Application Ref:	3/2021/0194	 Ribble Valley Borough Council www.ribblevalley.gov.uk
Date Inspected:	04/03/2021	
Officer:	RB	
DELEGATED ITEM FILE REPORT:		REFUSAL

Development Description:	Change of use of one agricultural building to a dwelling under class Q (a) and (b).
Site Address/Location:	Daniels Farm, Preston Road, Alston, PR3 3BL

North East Elevation
scale 1:100
0 1 2 3 4 5m

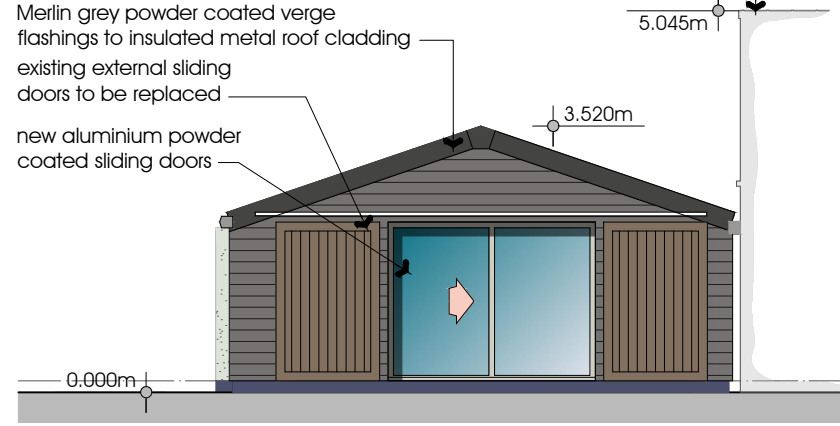
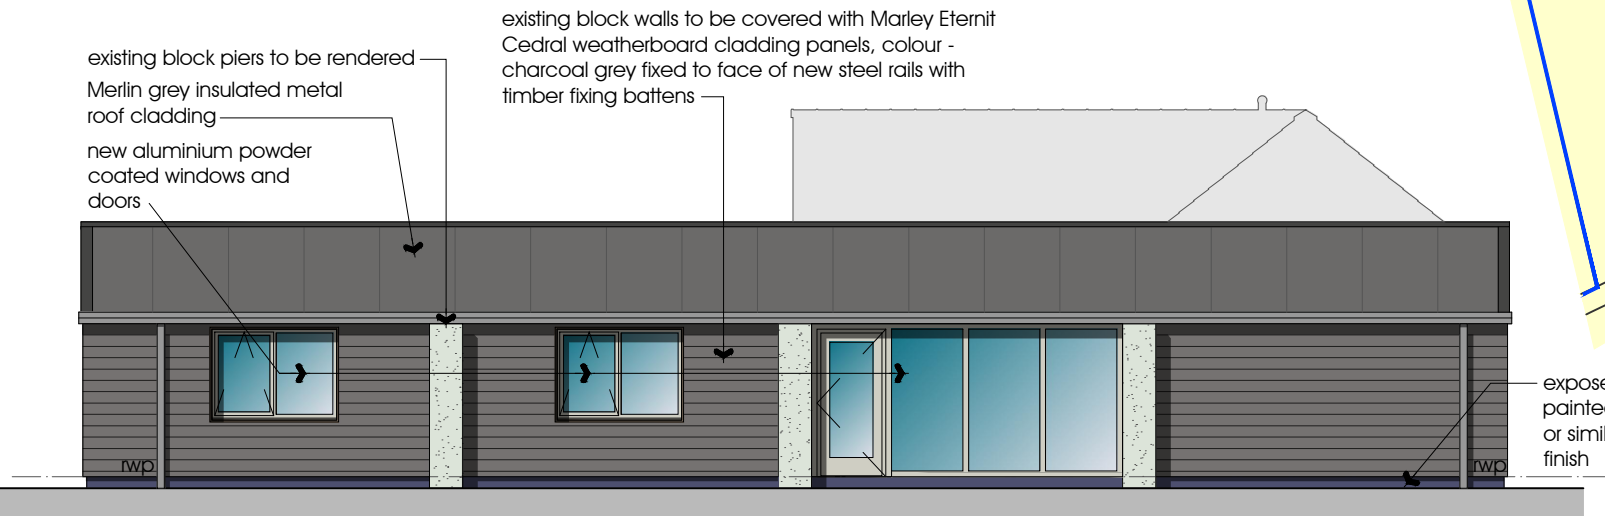
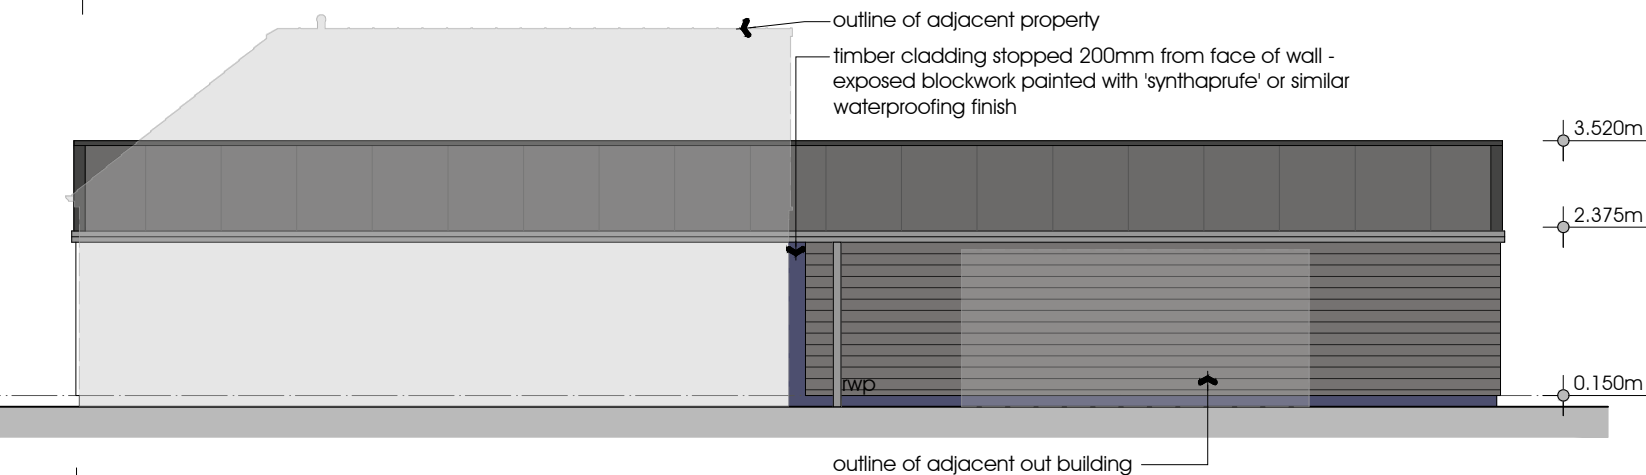
The proposed conversion makes use of the existing openings on the north east and south west elevation and proposes the insertion of new openings to the north west elevation. These include; one new aluminium powder coated window to serve the master bedroom to the rear of the dwelling; one new powder coated aluminium window to serve the second bedroom and one new aluminium powder coated door and set of bi folding doors serving the dining area. It is also proposed to externally clad the walls with Cedral weatherboard panels in a charcoal grey colour and a merlin grey insulated metal clad roof. It is accepted that inevitably new openings are required in order for the dwelling to be habitable and therefore it is considered that the conversion makes use of existing openings and proposes an acceptable amount of new openings. It is also considered that the proposed Cedral cladding and metal roof is considered appropriate for the location of the site.

Indicative Block Plan
scale 1:500

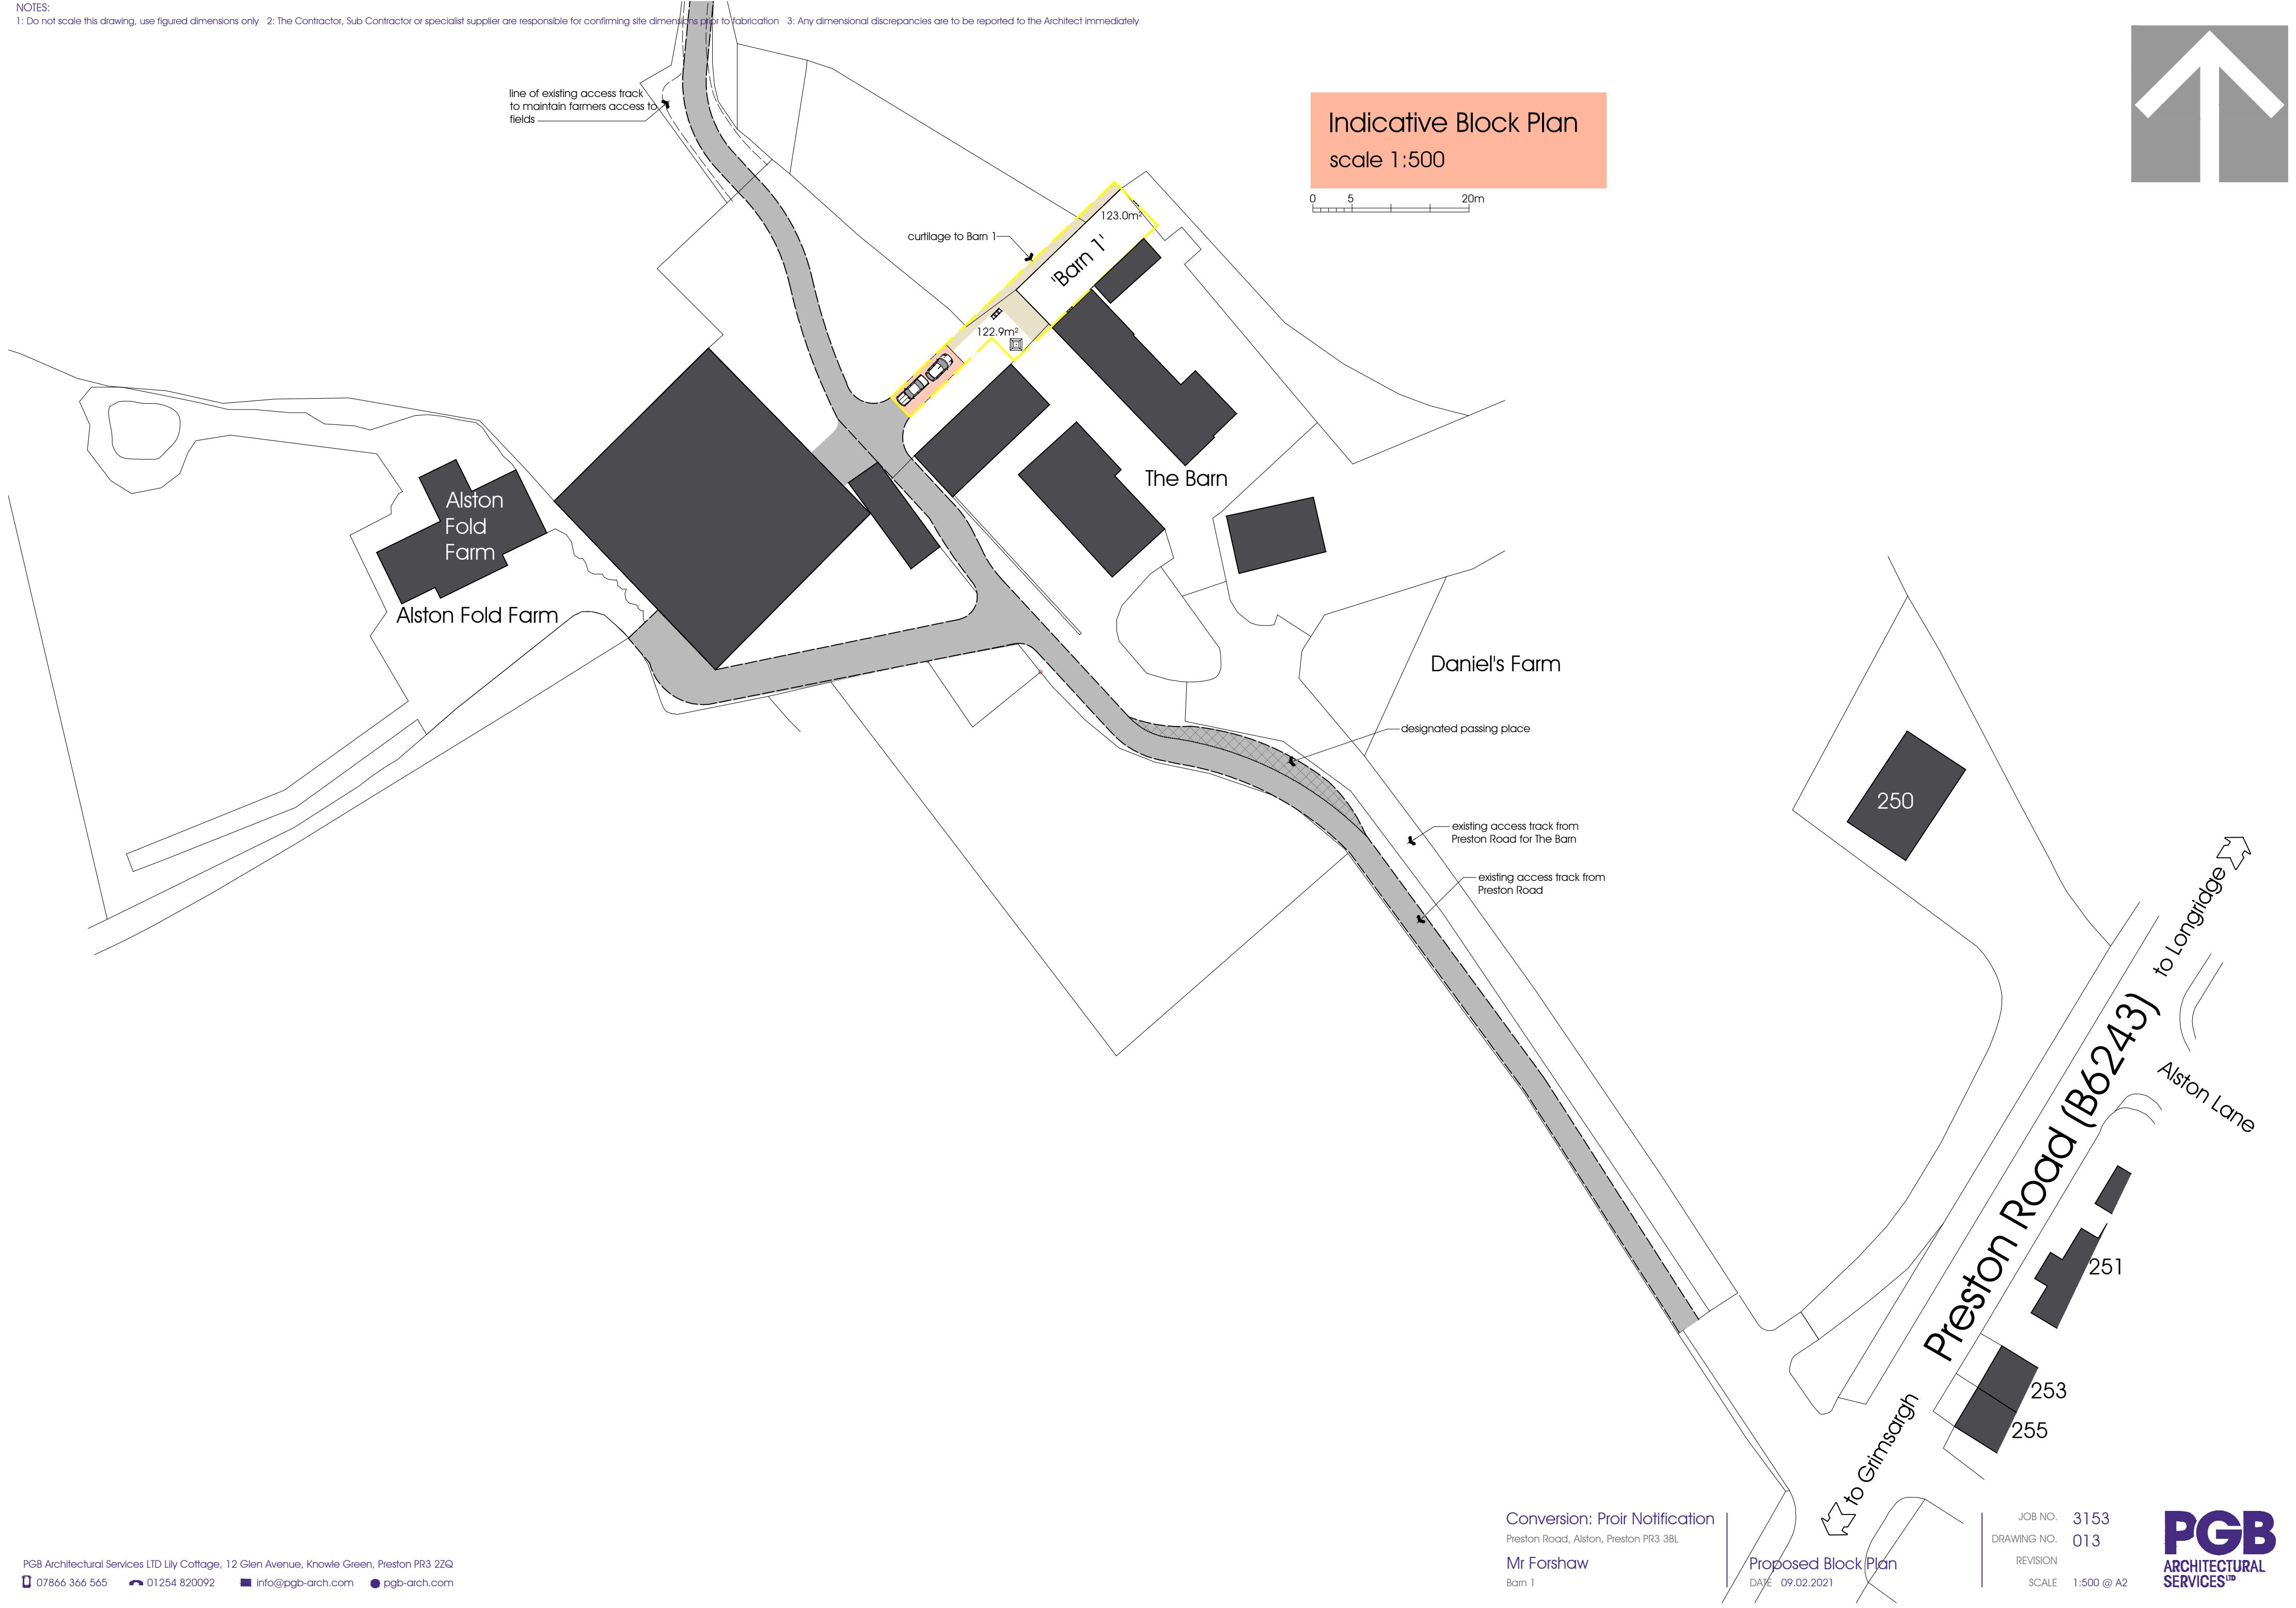
The dwellinghouse would be sited to the rear of the existing residential property at the site approximately 15 metres from the access track and the agricultural buildings are approximately 20m-25m from the proposed dwelling. It is considered that due to the siting of the dwellinghouse away from the access track and buildings that the agricultural activities that may take place surrounding this dwellinghouse would not result in unacceptable levels of noise, odour and disturbance and is therefore considered to be acceptable.
